**Consultation Response from KC,  
Highways Development Management**

**2023/93797 Former Liberal Club, 14, New Road, Kirkheaton, Huddersfield, HD5 0HP**

**Erection of extensions and alterations to former club to form 6 apartments**

**Date Responded: 04/04/2024**

Ground Floor Plan - 1:100

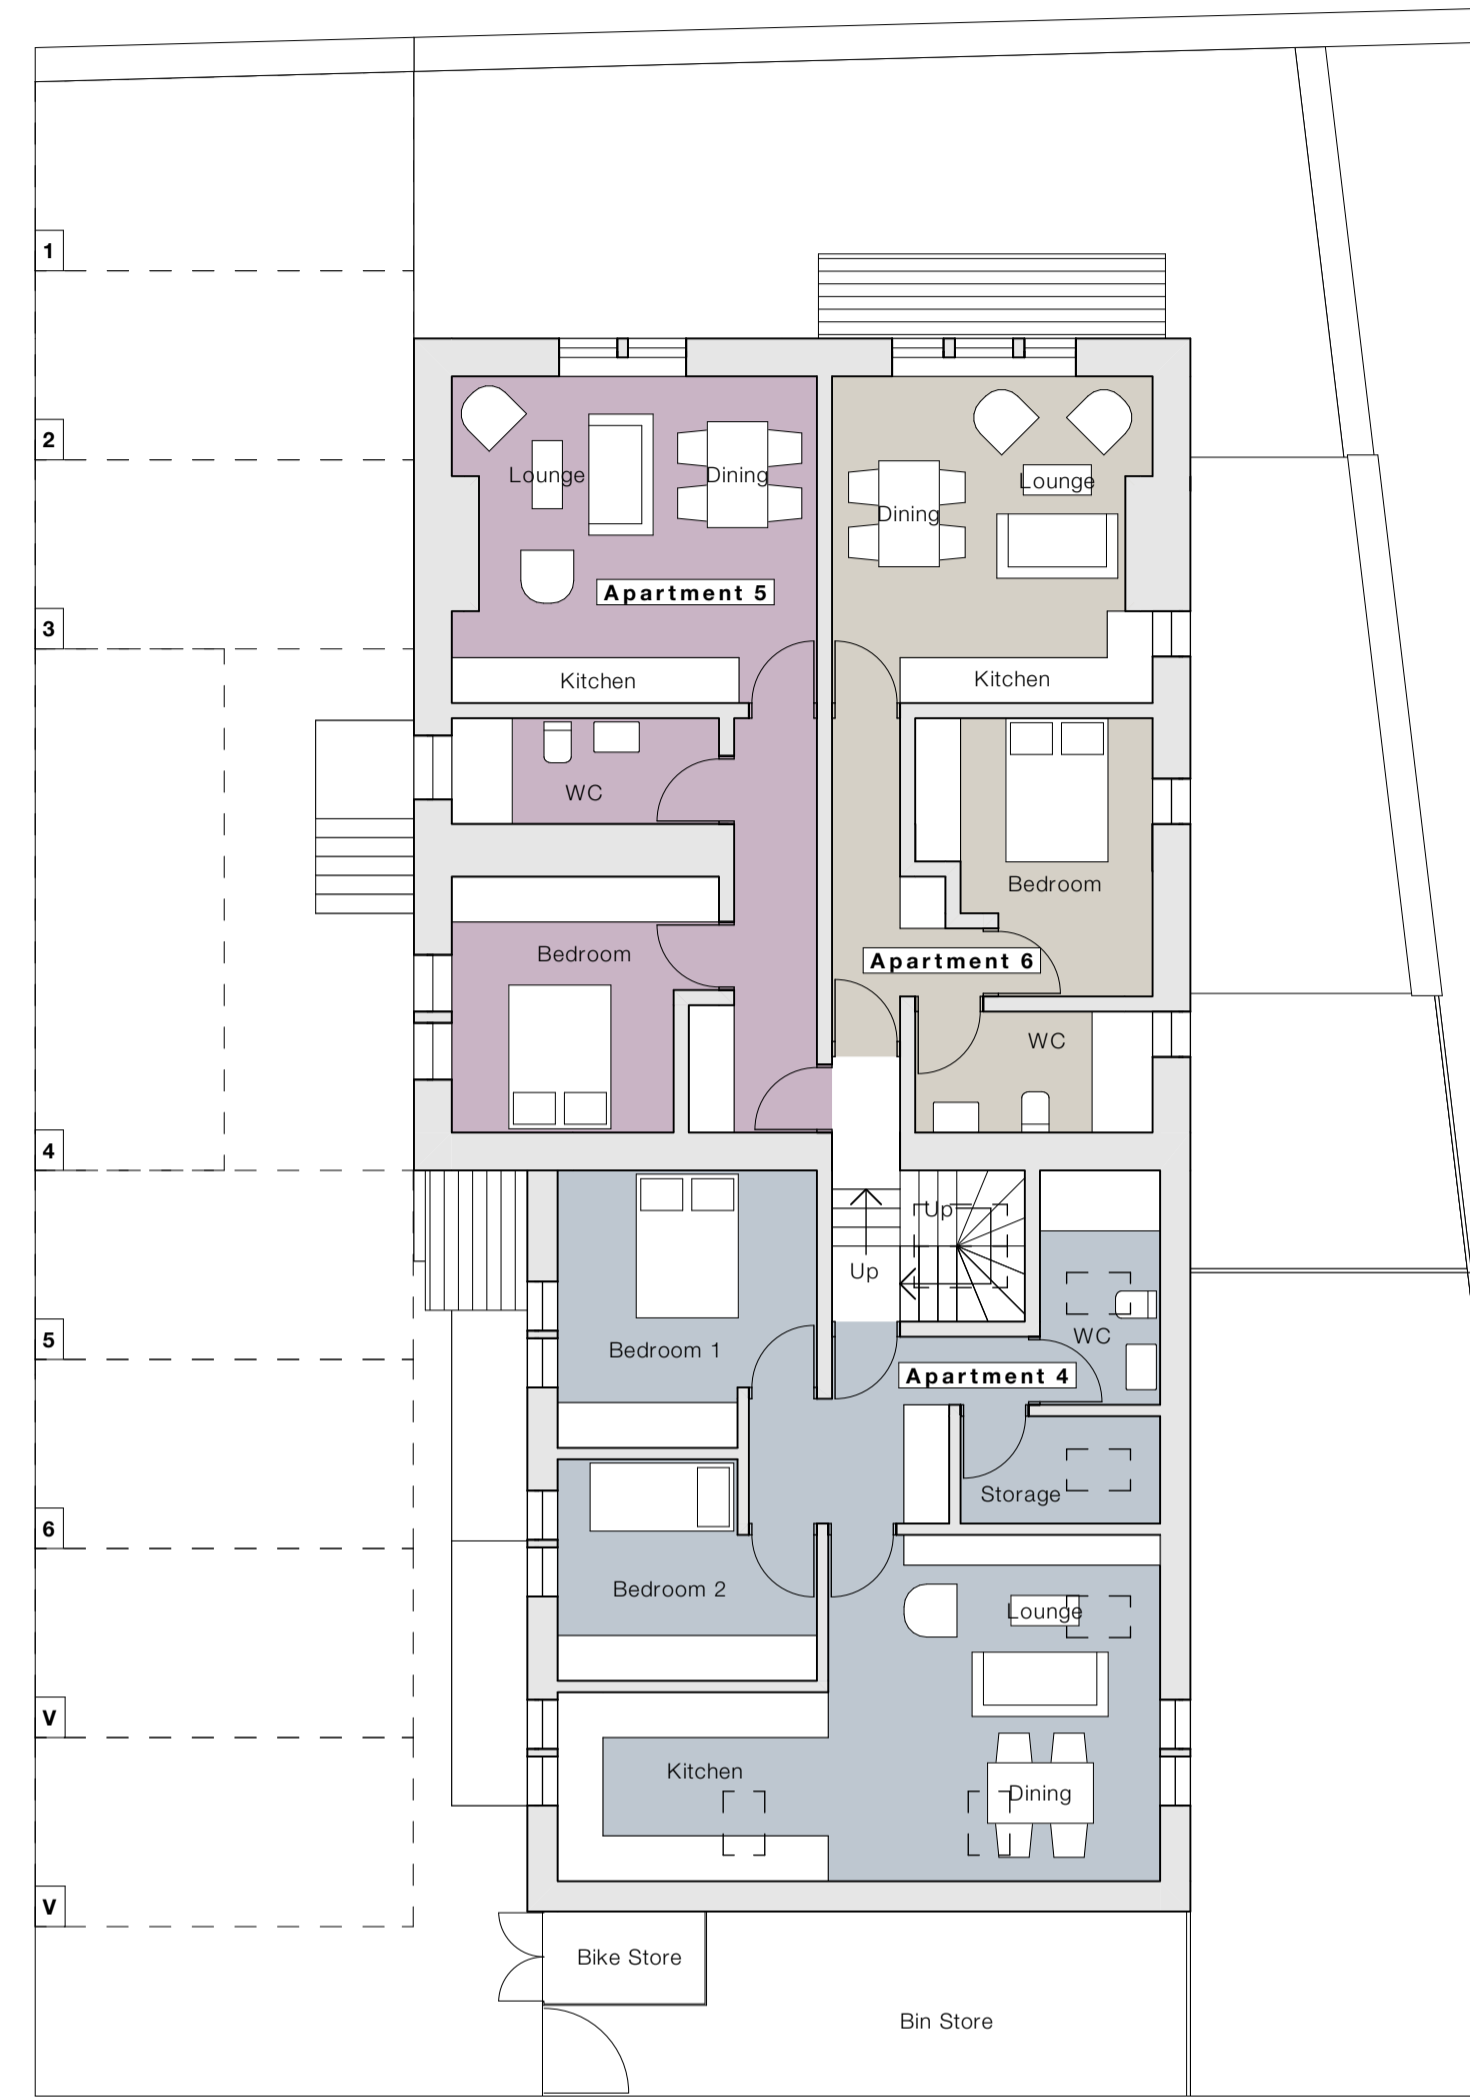
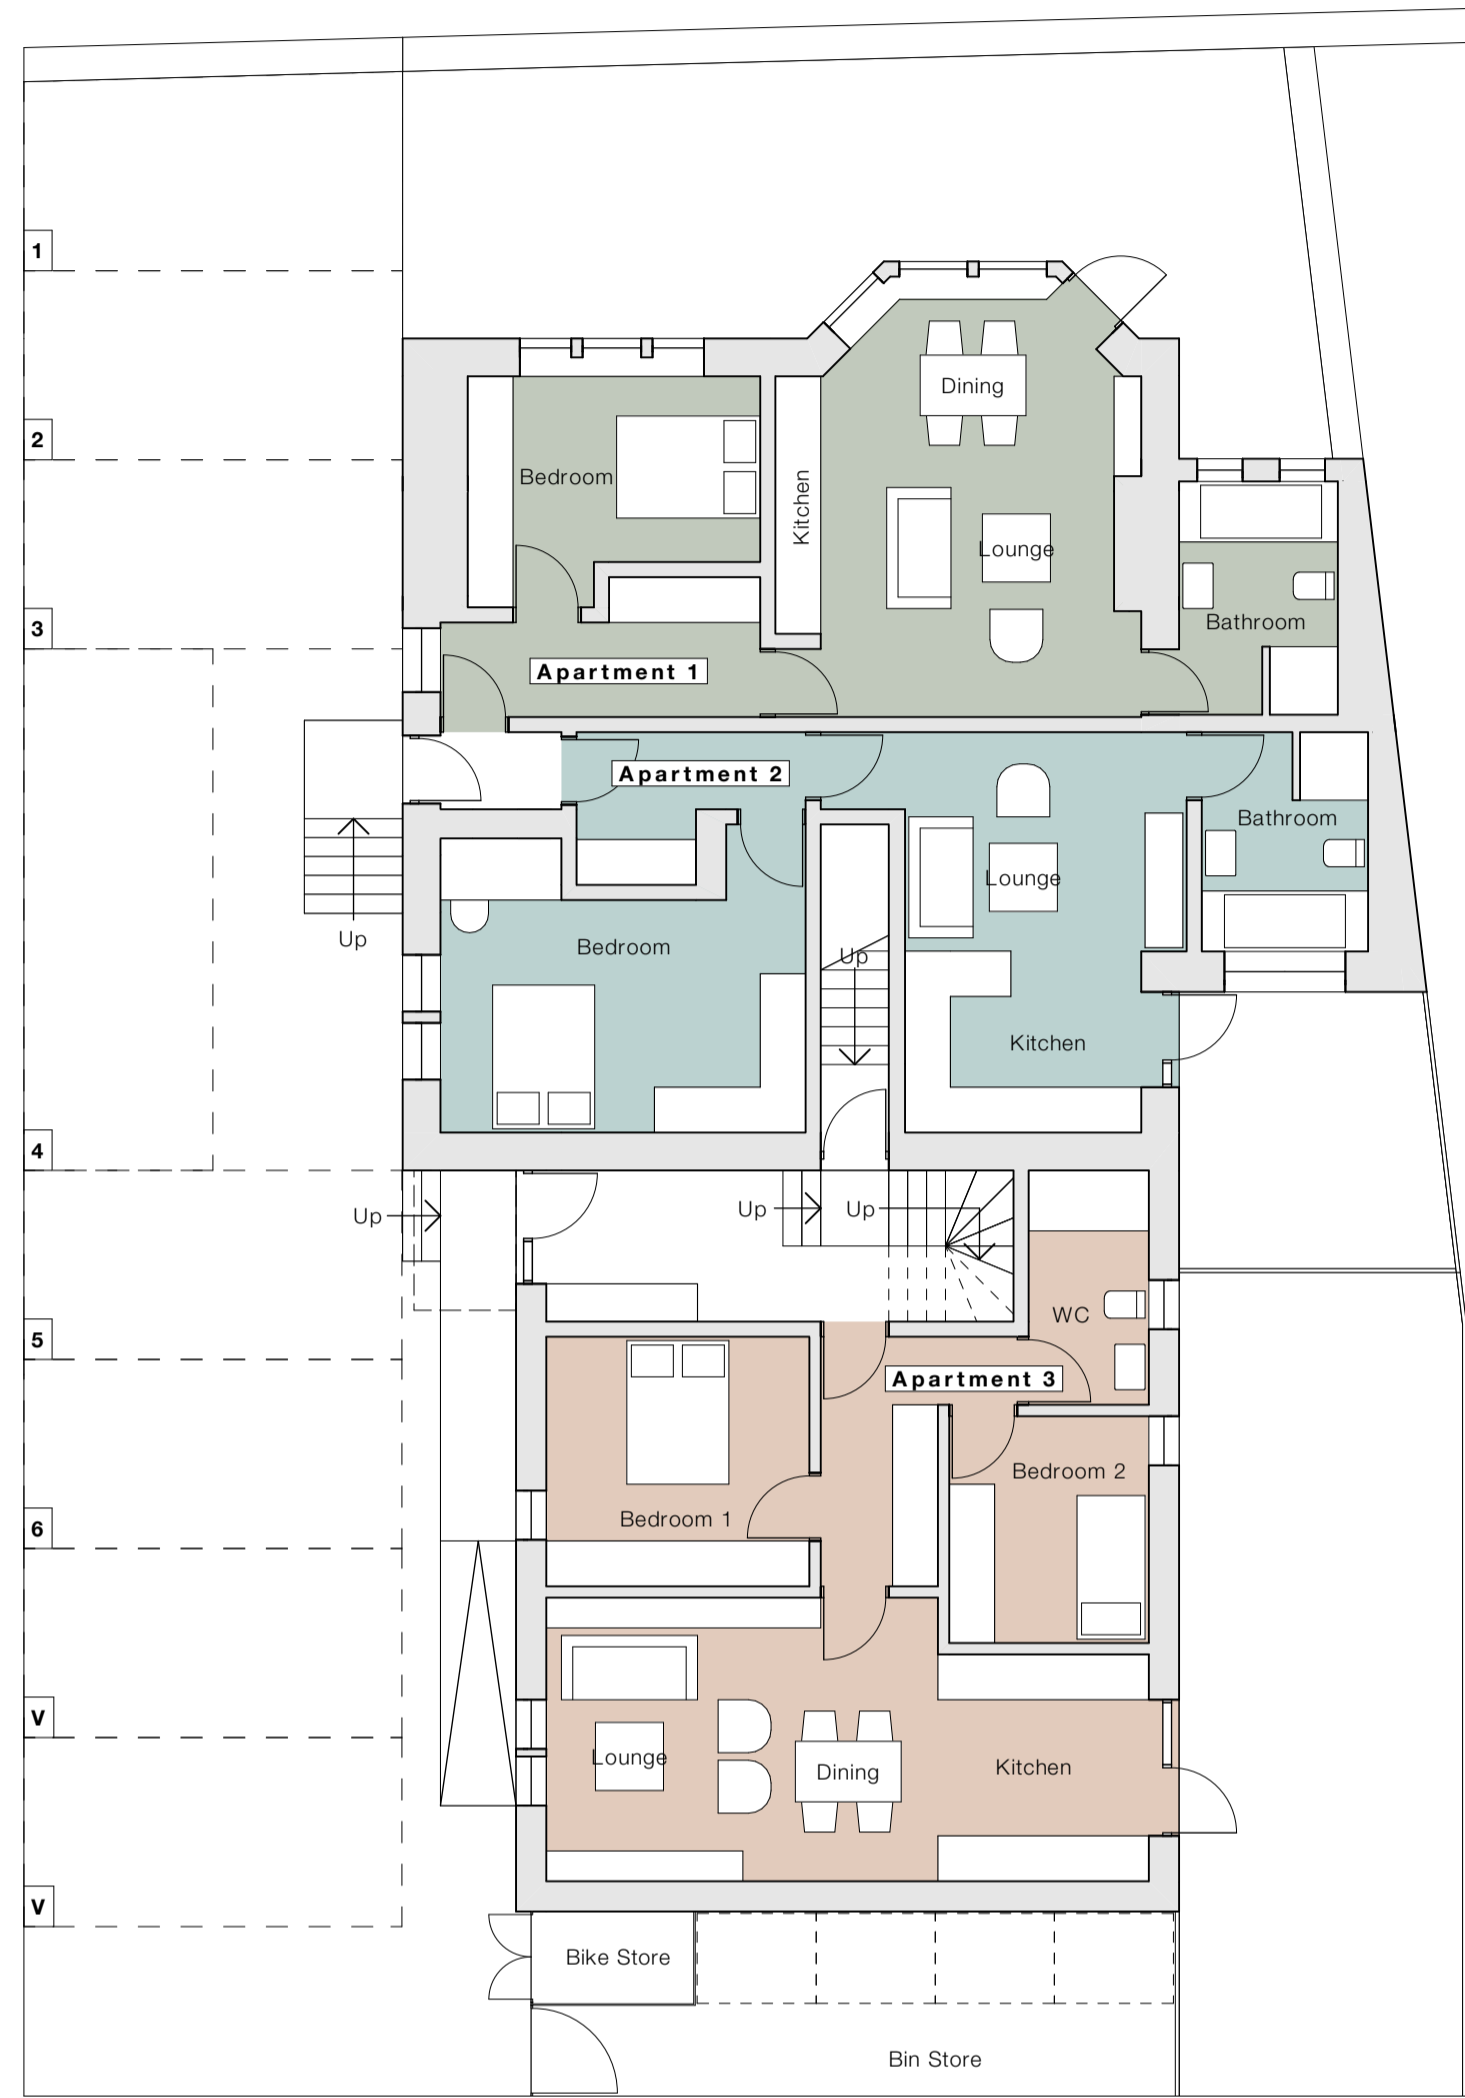
The site takes access via St Johns Avenue with parking provision for 6 vehicles plus an additional 2 visitor spaces, this is considered sufficient for a development of this size.

Further to a pre planning application on this site it was advised on the requirements for a suitable sized refuse storage area. The Councils Waste strategy team have advised again that the current bin store is not large enough to accommodate the required sized bins. Guidance indicates the floor space for 1 no 1100ltrs wheeliebin is 1575mmx1190mm with space required to manoeuvre the bins within the store. The proposed store on the plan shows overall dimensions of approximately 2.2m x 1.5m with a gate width of 1.2m. As such it suggested a suitable condition to ensure this issue is dealt with be recommended.

“Before development commences, details of suitable storage, bin presentation points and access for collection of wastes from the dwellings hereby approved shall be submitted to and approved in writing by the Local Planning Authority. The approved details shall be provided before first occupation and shall be so retained thereafter.”
